From: Amanda Scholes on behalf of Planning.Responses
Sent: 17 March 2021 14:10
To: Planning Scanning
Subject: FW: Planning Consultation on: CM/11/21/DOC

Application No: CM/11/21/DOC

Site Address: Scyld Horsemere Green Lane Climping BN17 5QZ

Description of Works: Approval of details reserved by condition imposed under CM/21/19/PL relating to conditions 11-surface water drainage scheme, 12-discharge of flows to water courses or for the culverting, diversion, infilling or obstruction of any water course on or adjacent to site & 13-maintenance and management of surface water drainage system.

DRAINAGE GA

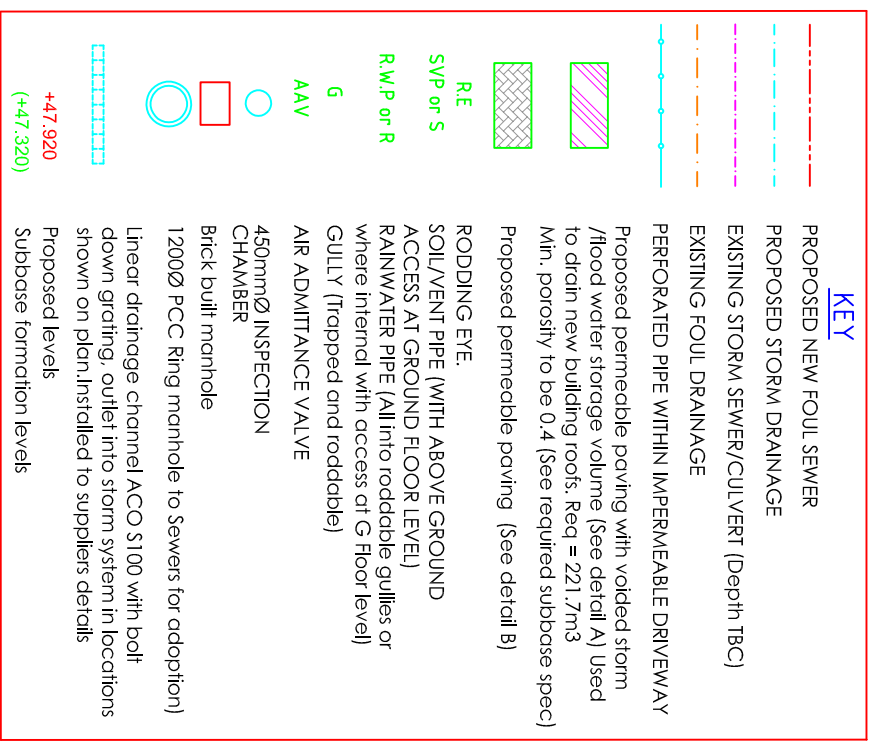
4. Please detail finish and formation levels of permeable paving on plan.
5. Please make the permeable paving construction details clearer. I.e. please provide one which clearly details the driveway construction, and one which details the road construction. Both must clearly state minimum required sub-base depth.

6. Please detail all pipe diameters and falls on plan.
7. No connections are shown to/ from the permeable car park areas.
8. Please provide site specific construction detail drawings of the proposed headwall, this should include a plan and full cross section through the ditch. All headwall drawings should indicate existing bed level, and top of bank level.

HEADWALL STRUCTURE FOR OUTLET PIPE

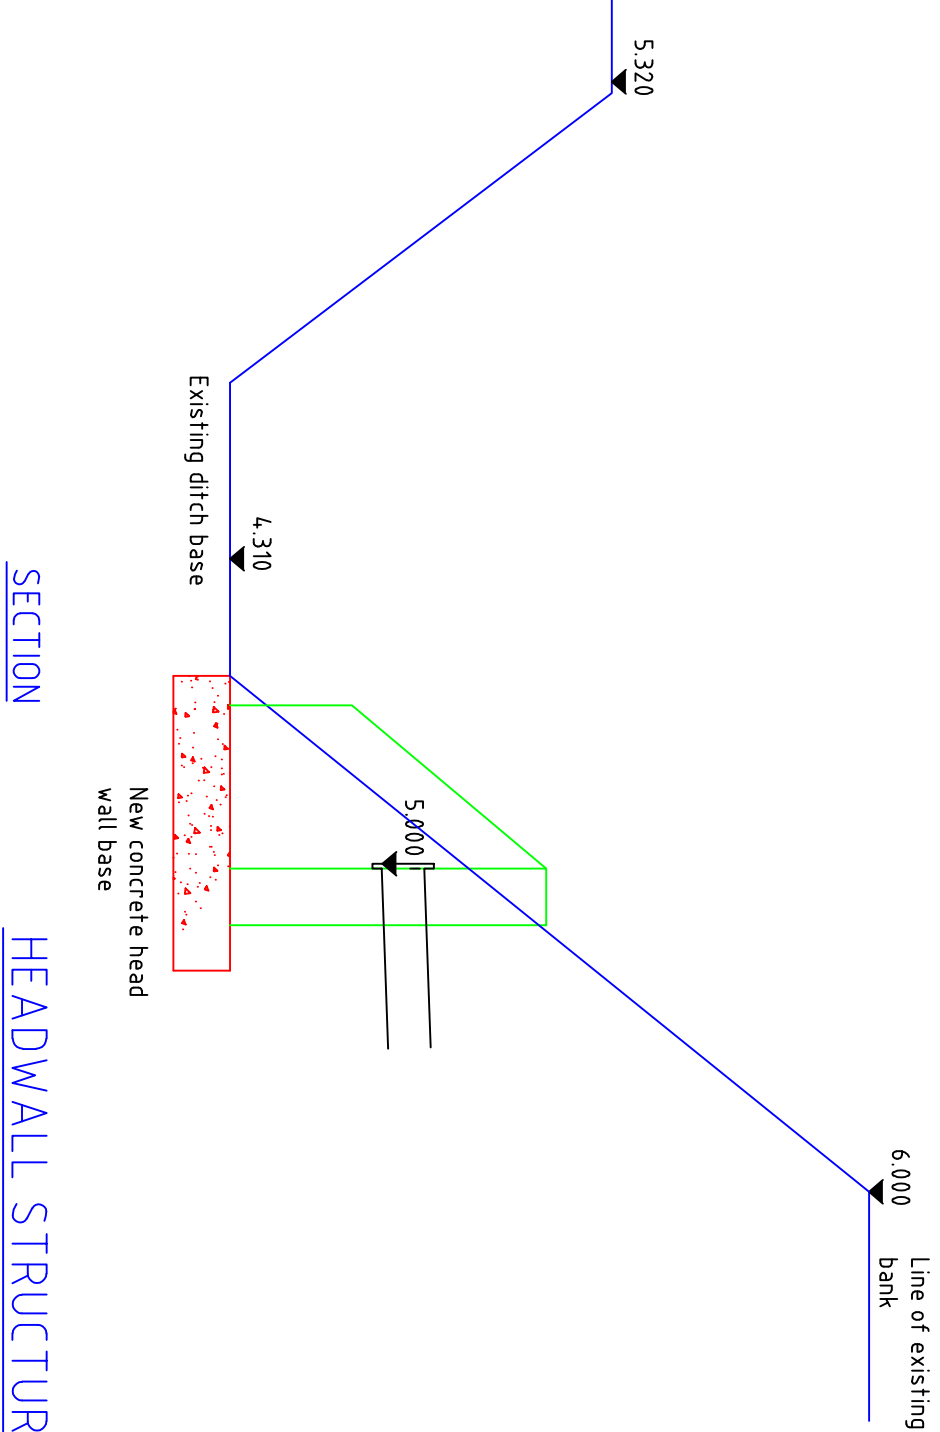
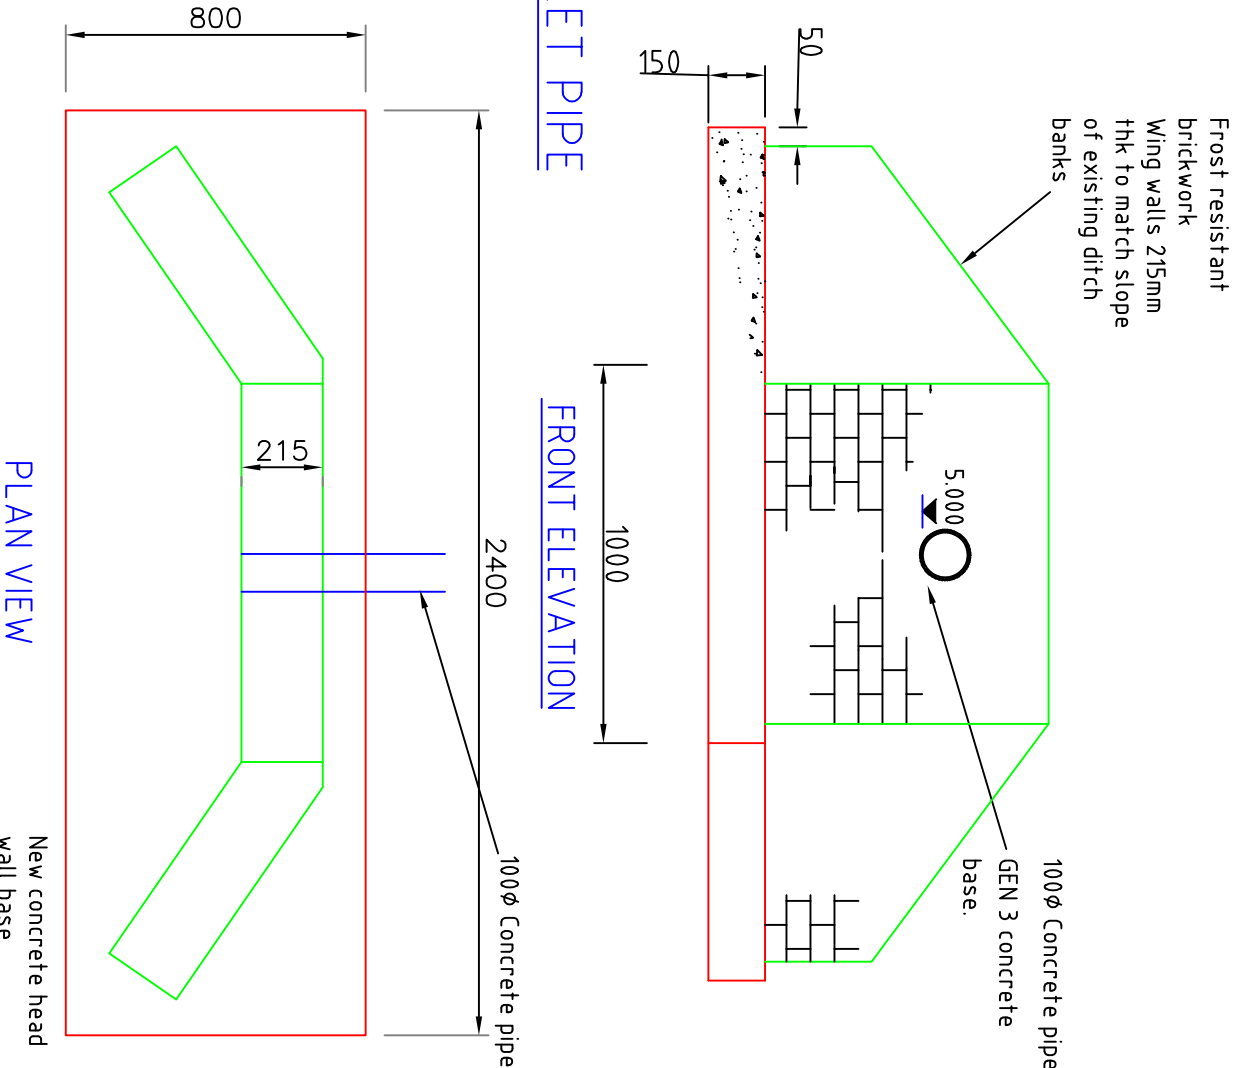
1. Please supply further details of the proposed culvert, i.e. diameter, invert level, and construction details- including headwalls.
2. It is stated on the plans that the culverting has been agreed, we do not believe this to be the case. Please supply evidence that an application for land drainage consent has been made for both the proposed culverting and outfall headwall.
